Application no: H19/0424/98

Location: Pt OS 8525, Broadgate Road
Sutton St Edmunds
Spalding
Lincs

Amendment: As built - plans for farm buildings
Dwg.Nos. SM.02B; WD1890/1A & /1B

TOWN AND COUNTRY PLANNING ACT 1990
NOTICE OF ACCEPTANCE OF AMENDMENT

DRAWING NO.: **SM.02 B**

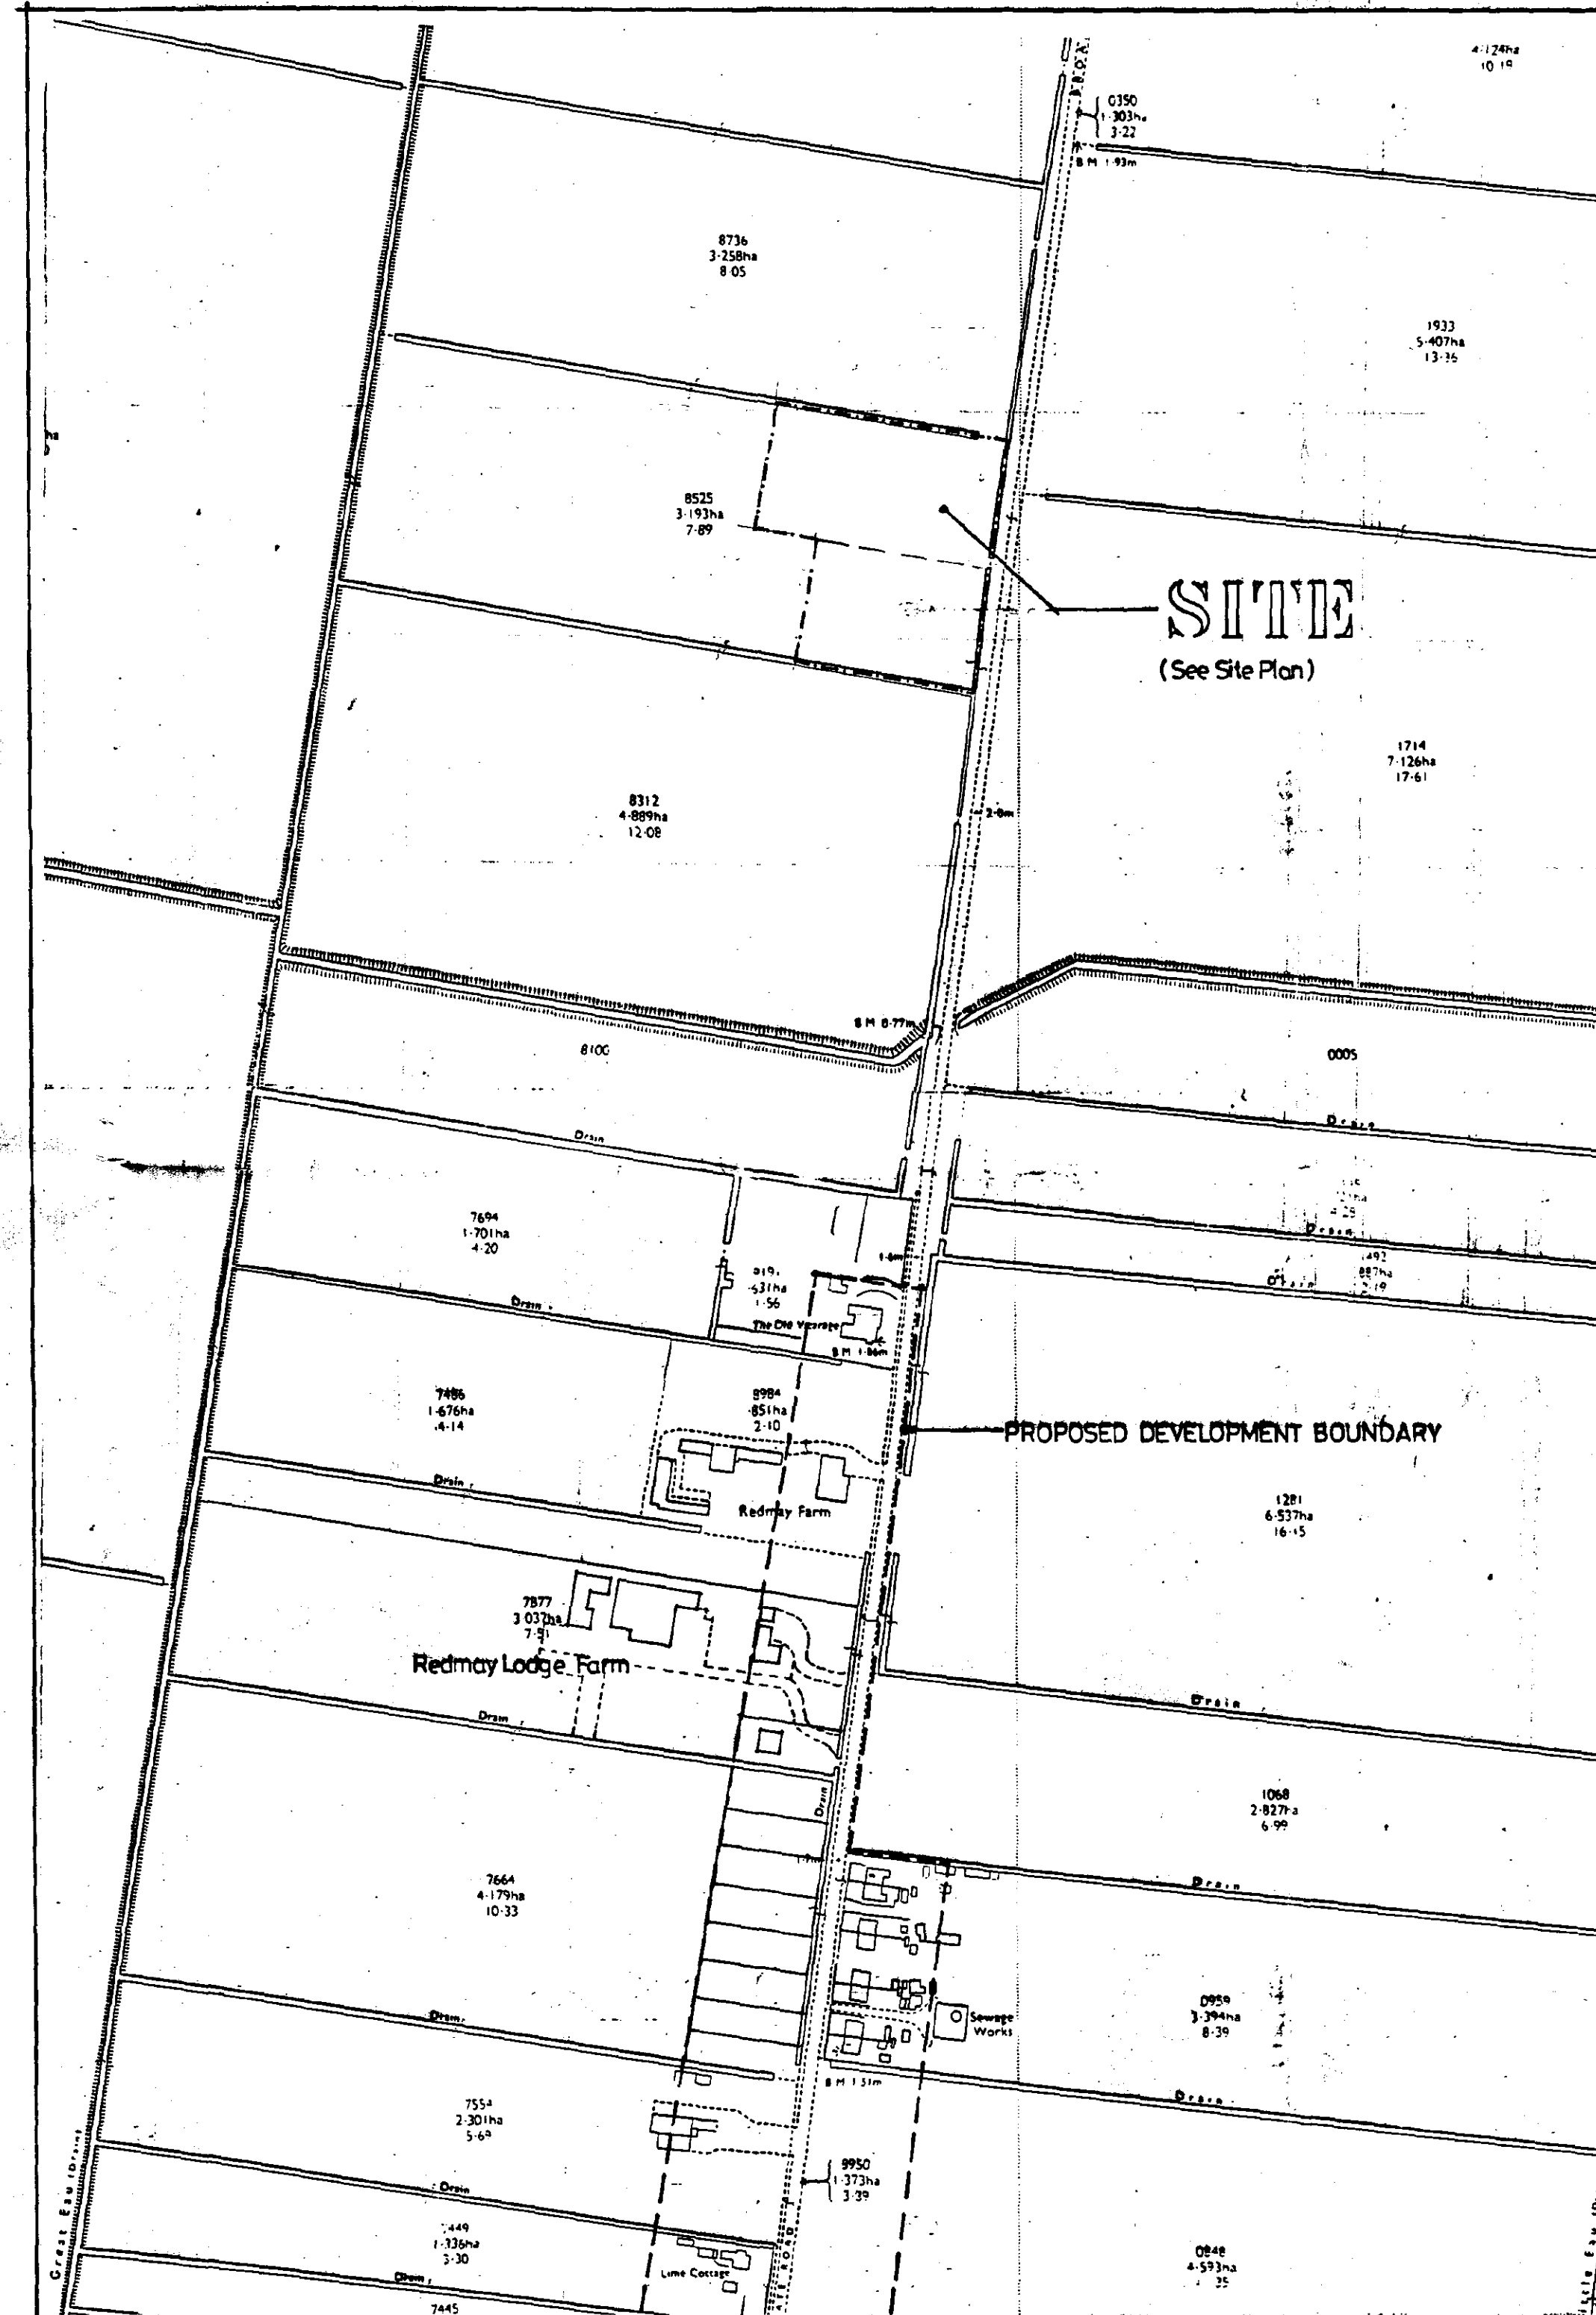
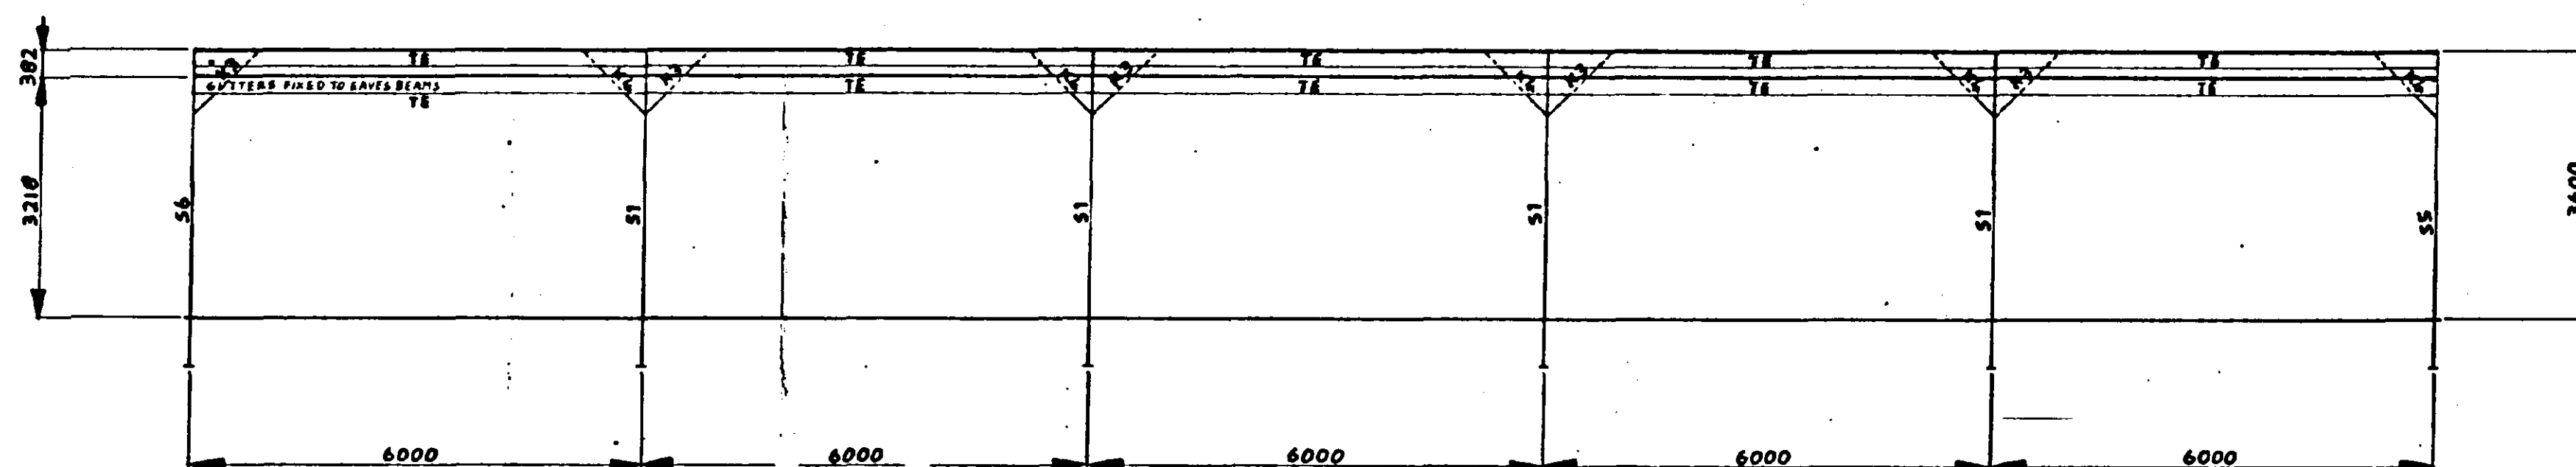
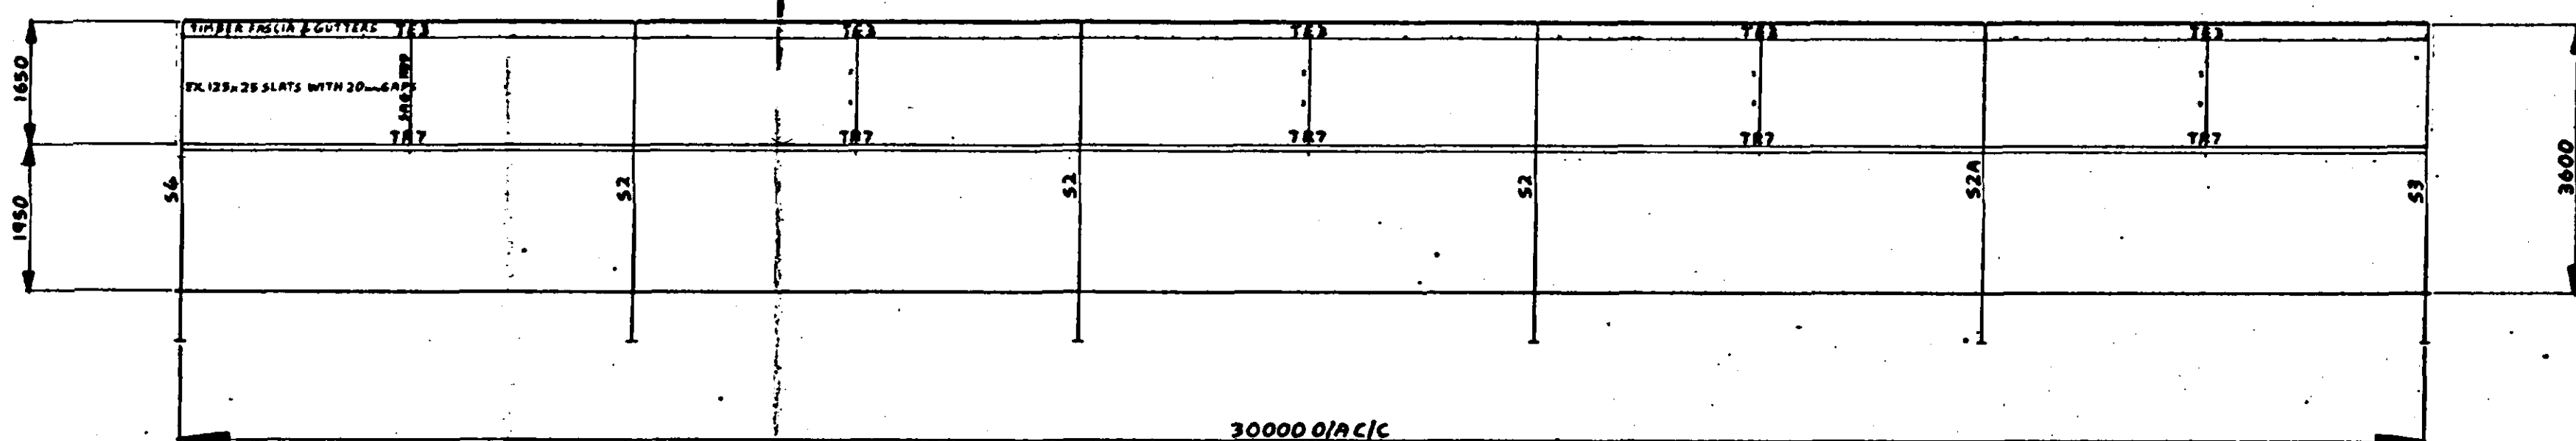
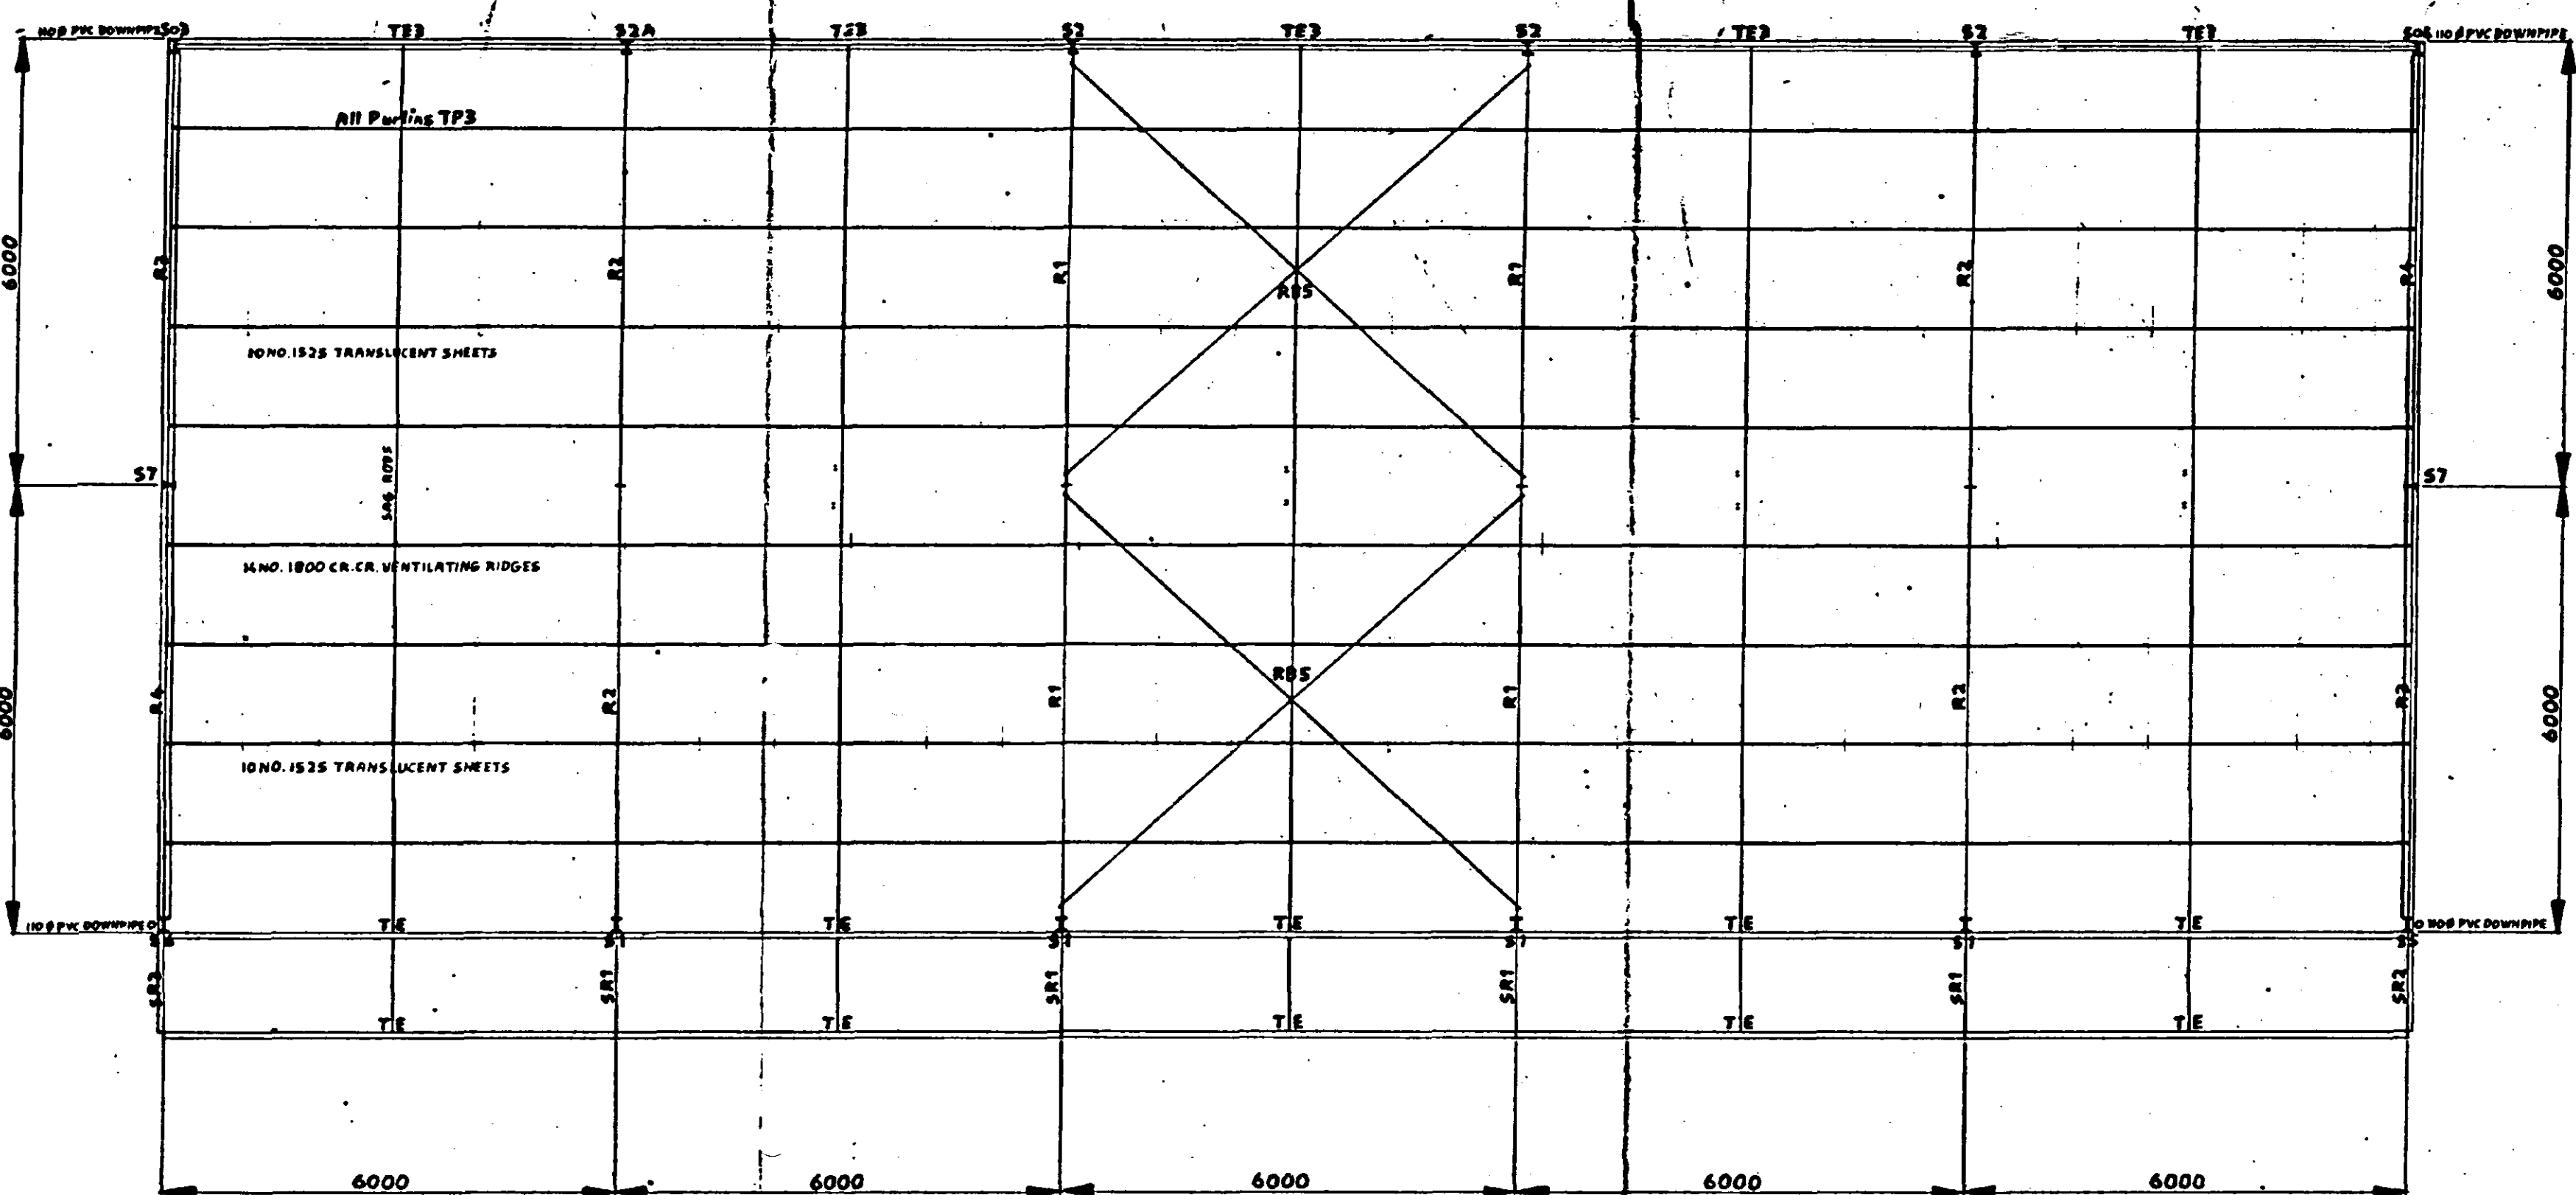
15. BUILT PLANS OF FARM
BUILDINGS.
